From:
To: [DCAdmin](#)
Subject: Villa Farm Planning application 2021/92086
Date: 12 April 2022 16:49:19

Despite the amendments to the above application , we wish to reiterate our objections to the proposal.

Front Elevation

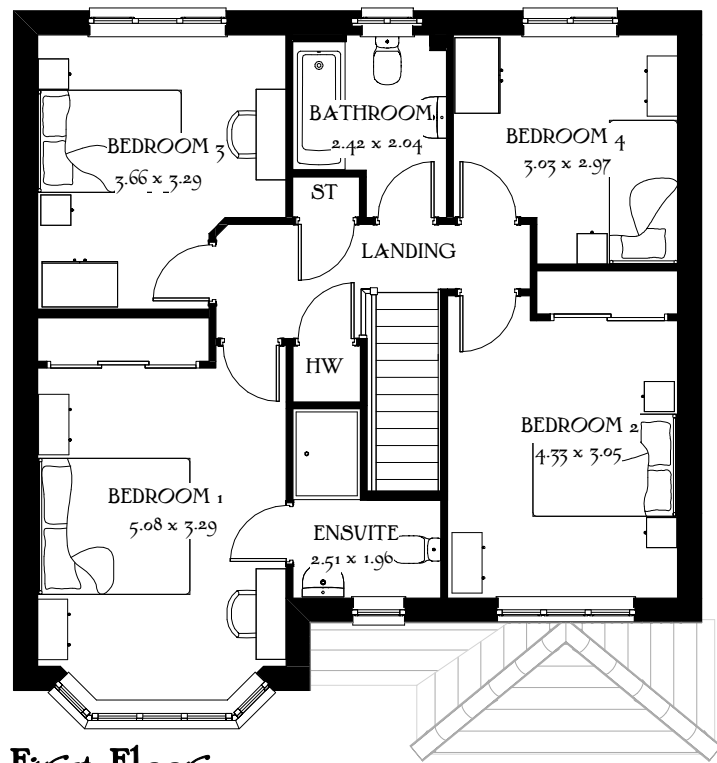
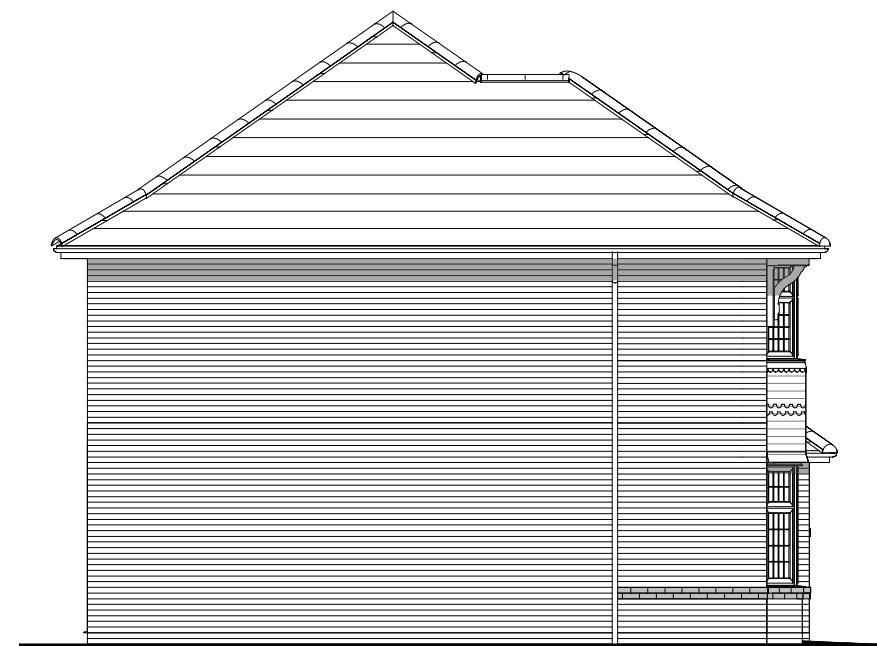
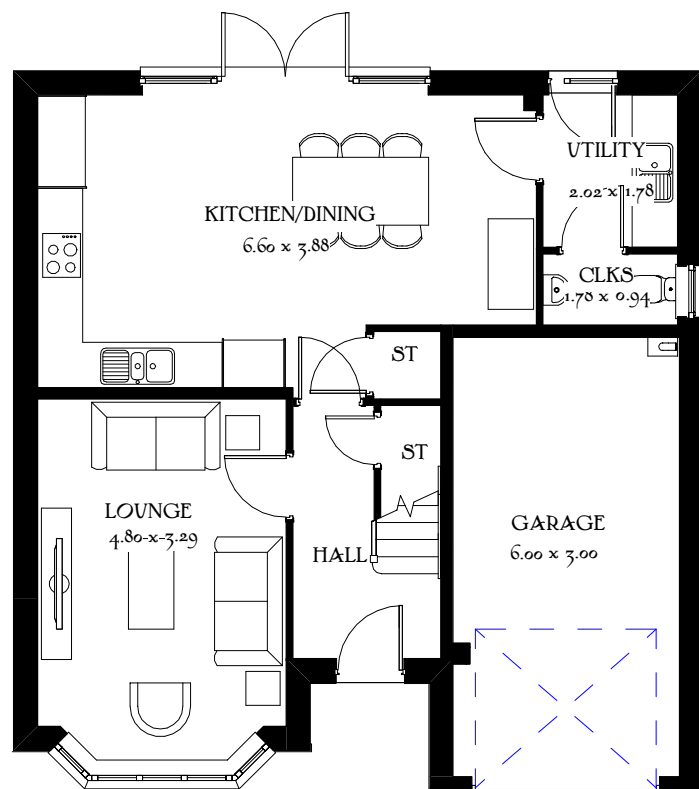
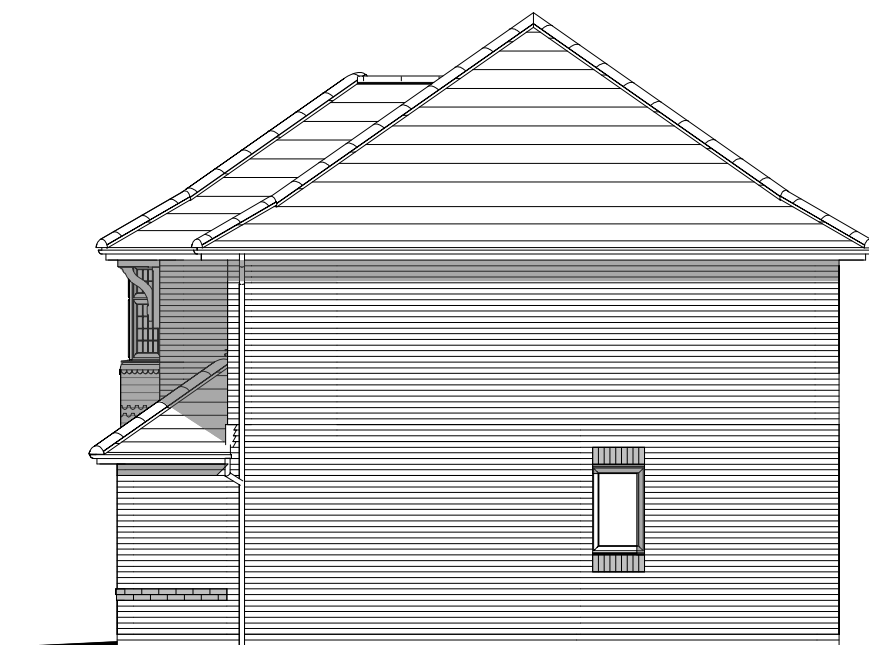
Generally it is unclear from the information provided what the proposal will look like, as there are no street scenes. The developers do not seem to care enough to even show a complete elevation of the terraced blocks which abut our northern boundary.

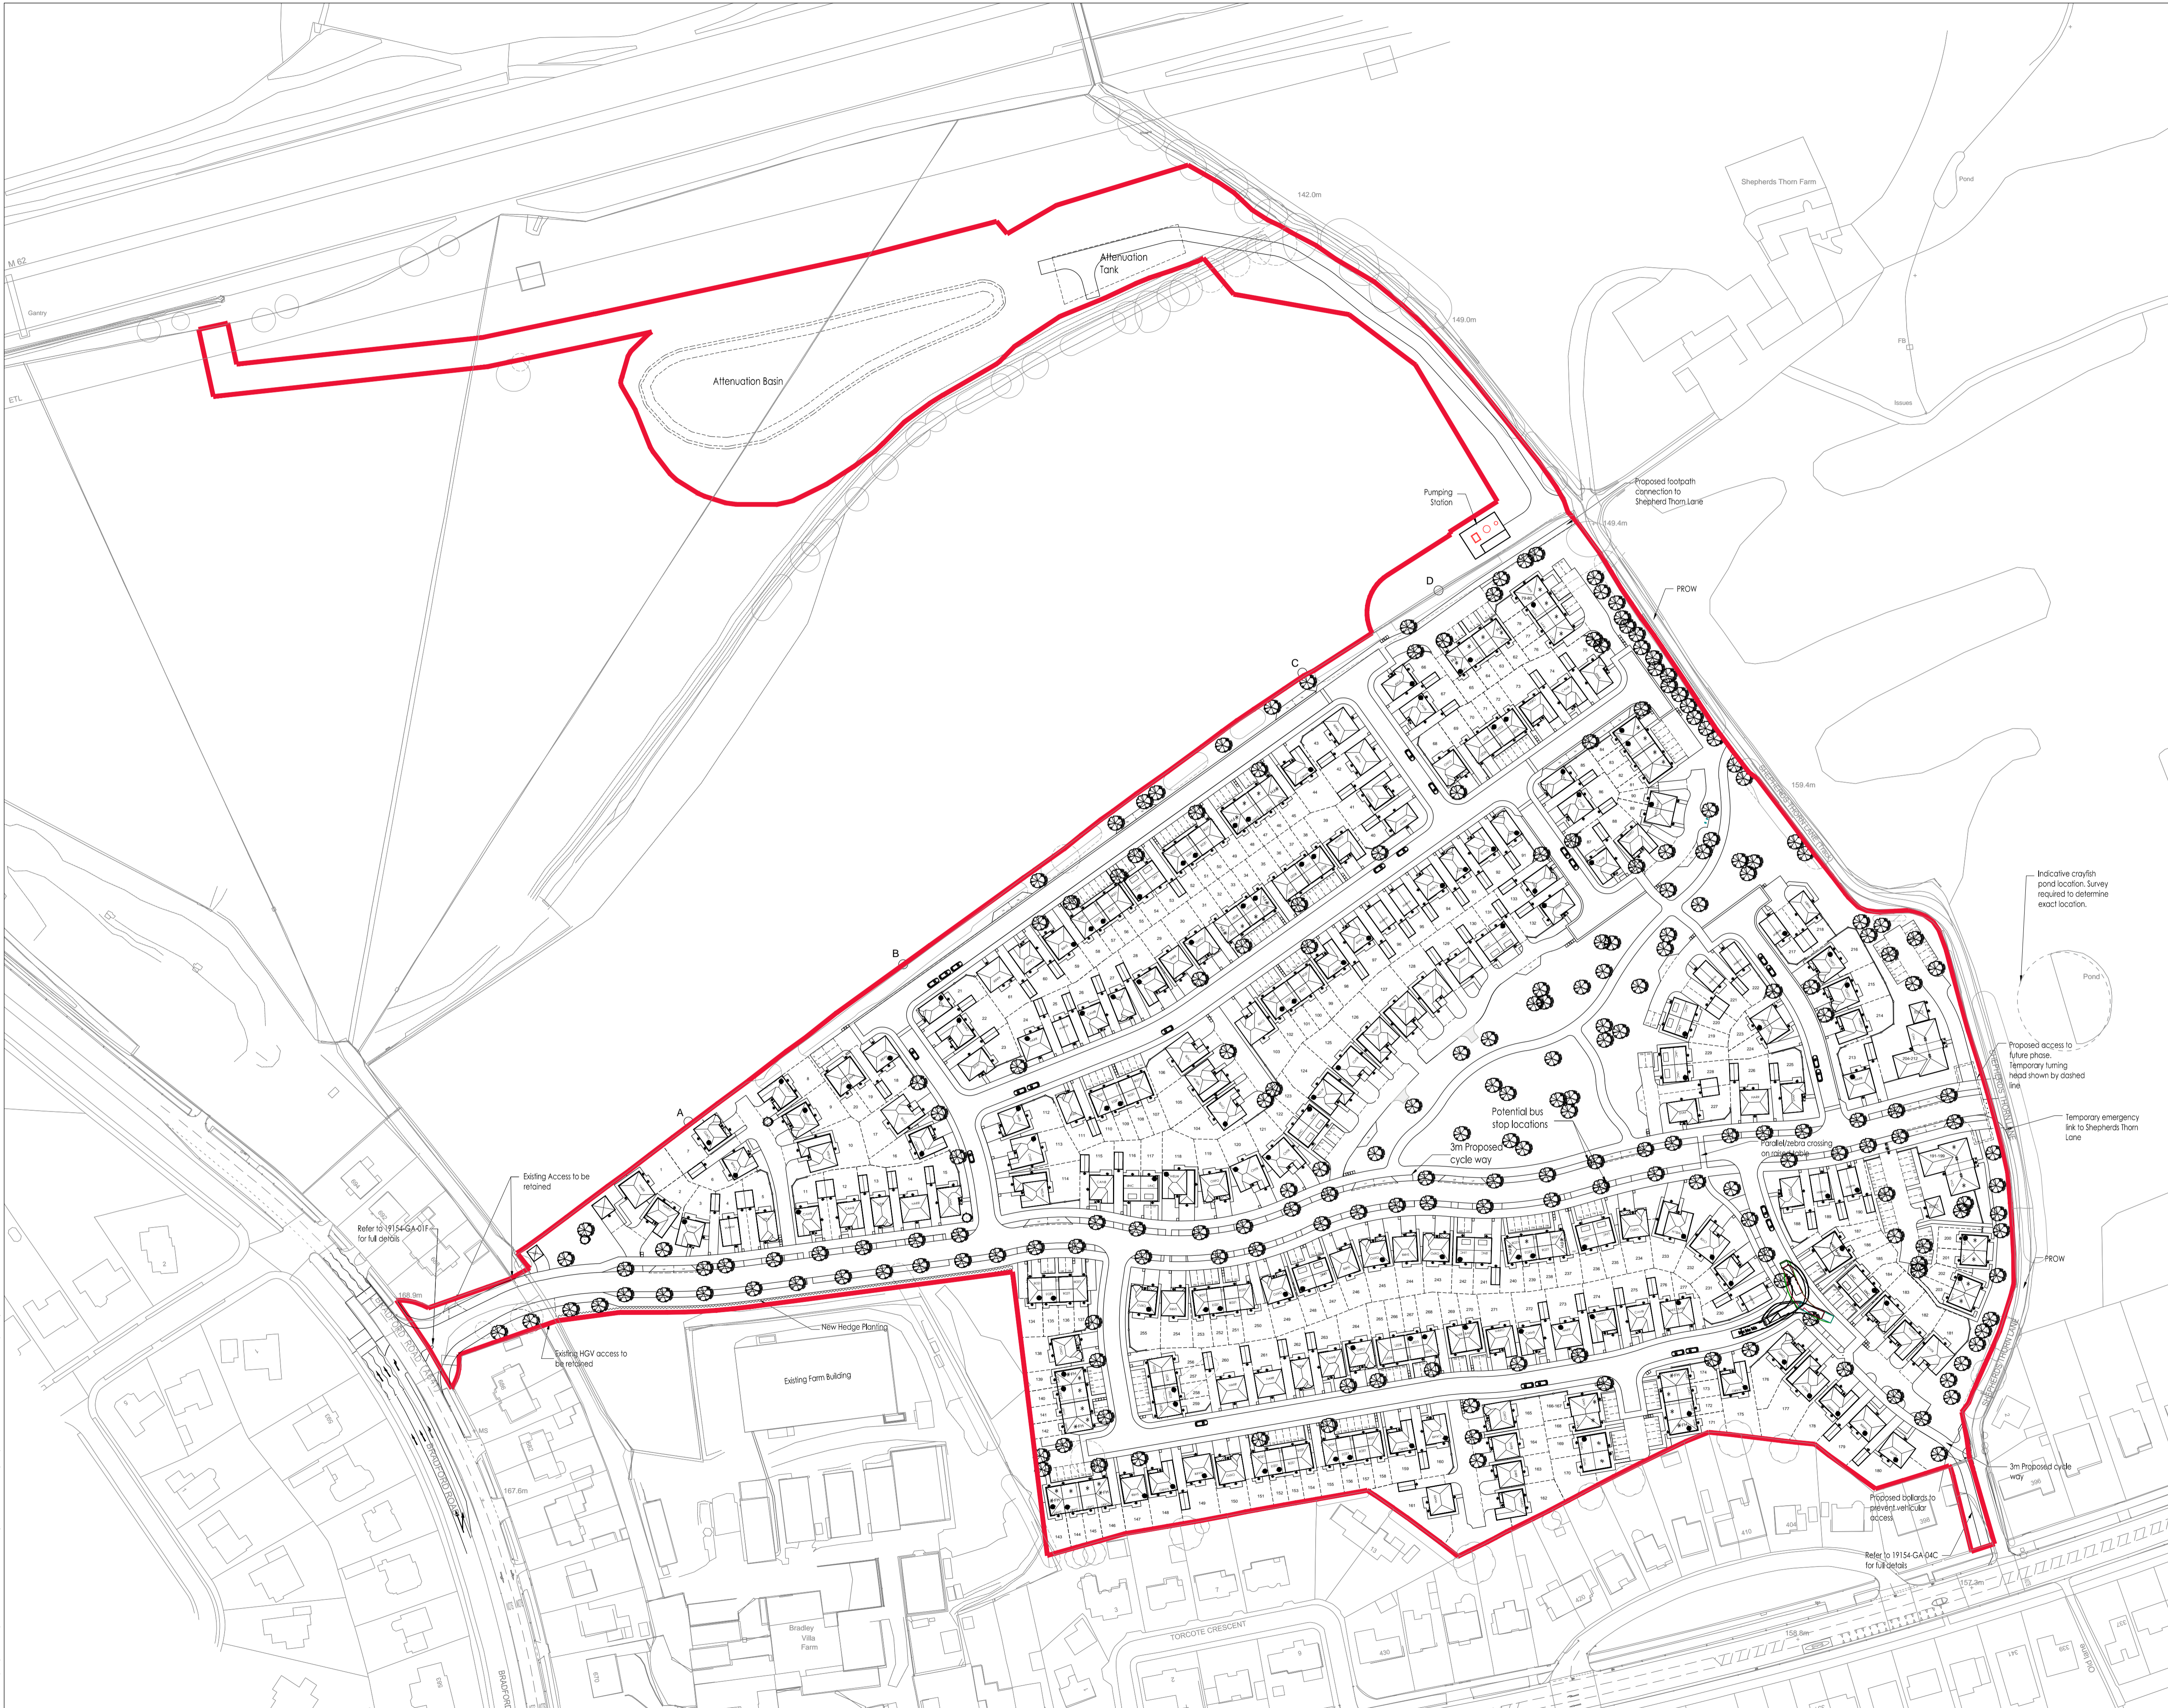
The impact on wildlife seems to be understated ,with the addendum bat report, only focusing on three nesting opportunities in trees. We regularly see bats foraging along the hedgerows of the southern boundary of the site, and have concerns about the apparent removal of this existing vegetation.

It is not clear from the layout, or landscape plan, what the intentions are on this boundary, and how it will impact on our garden.
